WEST SUSSEX COUNTY COUNCIL CONSULTATION

TO:	Arun District Council FAO: Aishwarya Reddy
FROM:	WSSC – Highways Authority
DATE:	24 February 2025
LOCATION:	Land opposite 19 London Road Bognor Regis PO21 1PQ
SUBJECT:	BR/13/25/PL Installation of 1 No new communications Kiosk with integrated defibrillator and advertising display. This application is in CIL Zone 4 (Zero Rated) as other development.
DATE OF SITE VISIT:	n/a
RECOMMENDATION:	Advice

14. Digital display operation

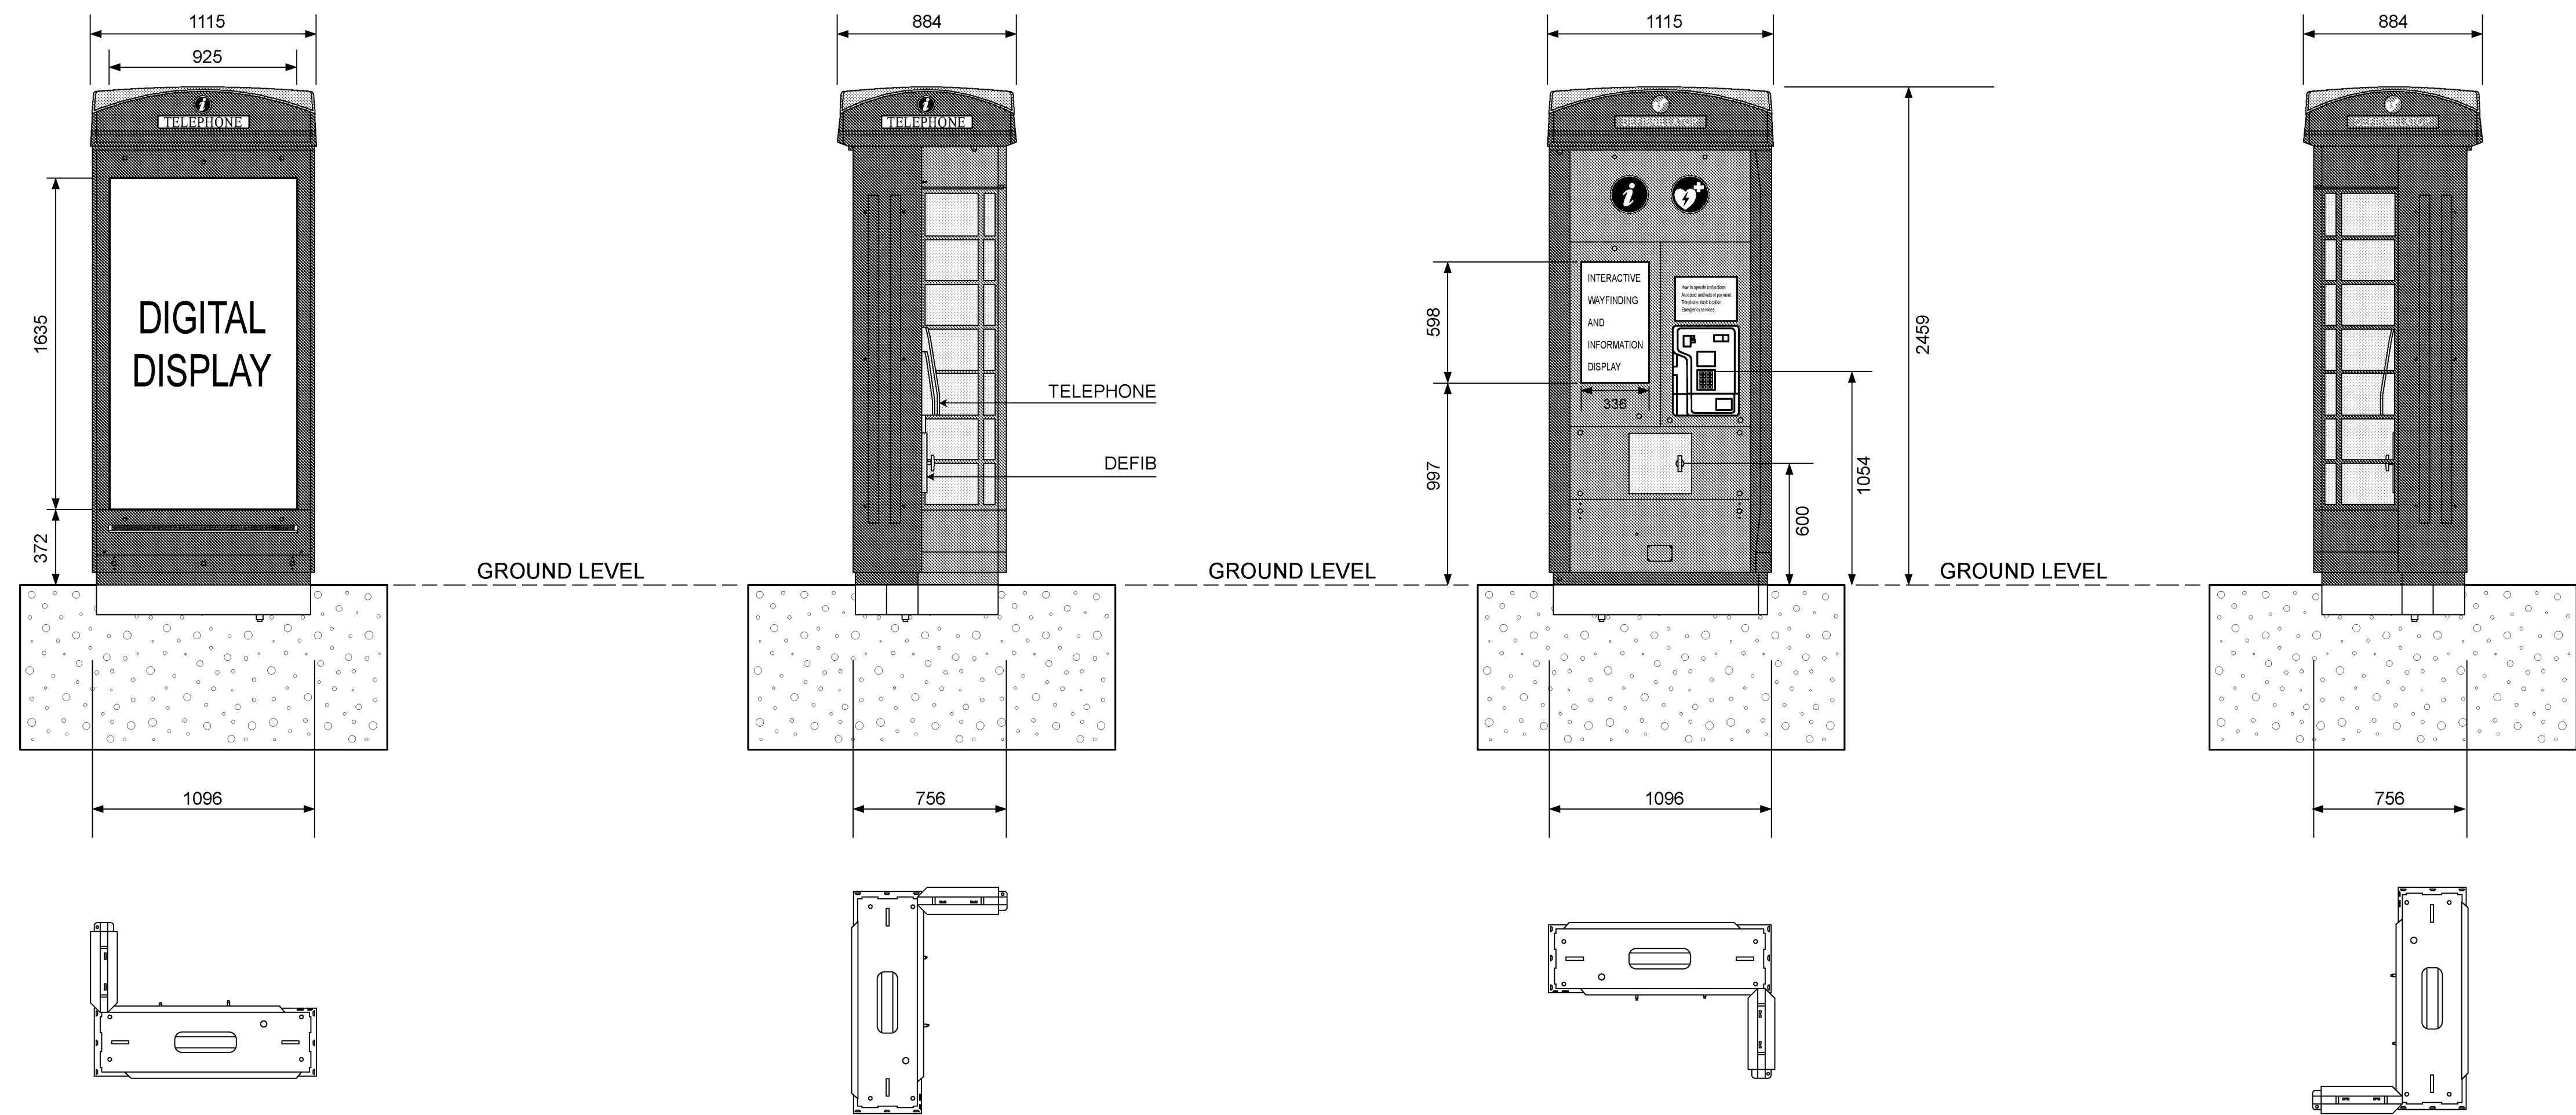
The advertisements within the Digital Display will be illuminated and are said to have a sensor which adjusts to ambient light levels, the associated documentation provided outlines that the light levels will adhere with recommendations laid out within PLG 05/23 The Brightness of Illuminated Advertisements including Digital Displays (2023). The advertisements will change every 10 seconds.

The Institute of Lighting Engineers' *Technical Report Number 5: Brightness of Illuminated Advertisements* (2015) should be referred to when a proposed illuminated sign will be visible from the public highway. The guidance states that the maximum daytime luminance level should not exceed 5000 cd/m². There is a table within the report which provides the recommended maximum luminance levels in **candelas per square metre (cd/m²)**, during the hours of darkness. The kiosk will be located within Bognor Regis which lies within Zone E3, which for under 10.00sqm results in a maximum allowed night time luminance of 600cd/sqm.

2. The intensity of the illumination of the signs shall not exceed 600cd/sqm during the hours of darkness

4. The panels displaying the advertisements shall not change more than every 5 seconds
